# KITTITAS COUNTY FIRE MARSHAL'S OFFICE

April 1, 2013

Re: Zentz Short Plat (SP-13-00003)

SHORT PLAT PREPARED FOR TERESA ZENTZ A PORTION OF THE NW 1/4 OF SECTION 20, TOWNSHIP 18 NORTH, RANGE 18 EAST, W.M.		
KITTITAS COUNTY DWN BY DLP/GW	DATE 03/2013	JOB NO. 13017
CHKD BY DLP	SCALE 1" = 100'	SHEET 1 OF 2

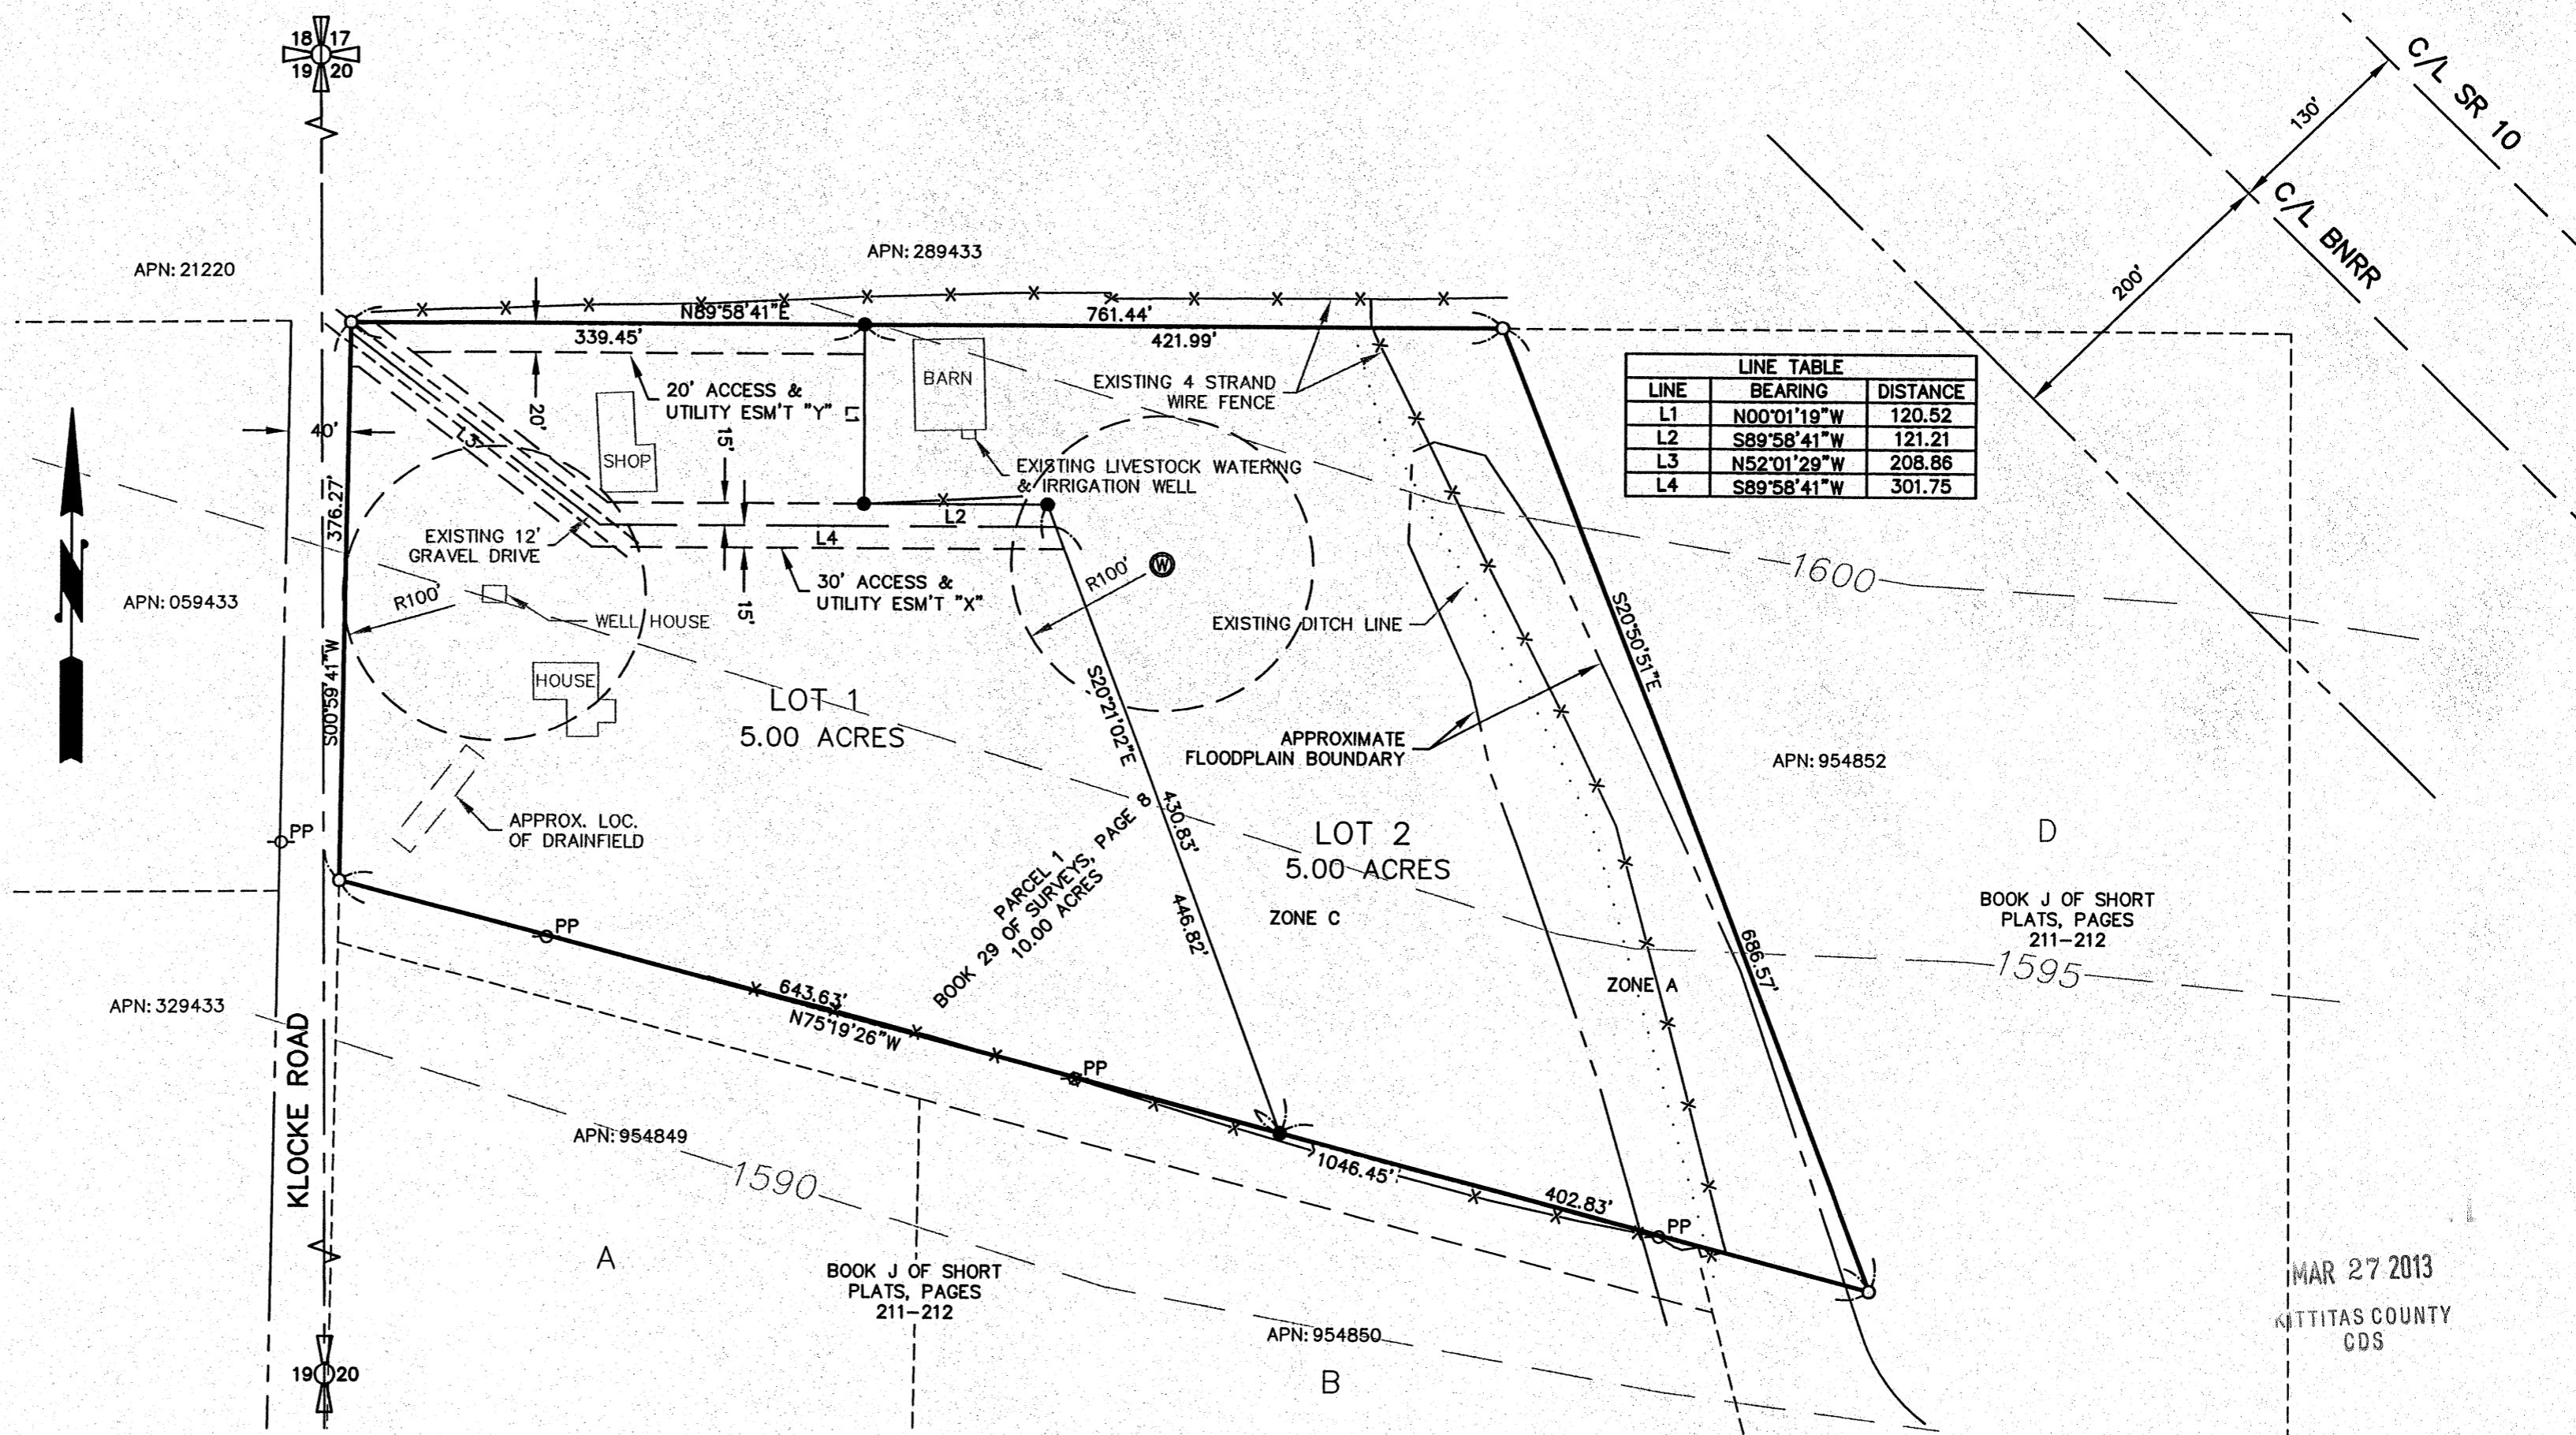
- The driveway for the new property must comply with Kittitas County Code, i.e. any driveway greater in length than 150' shall be no less than 16 feet in width.
- All future development must comply with the International Fire Code.
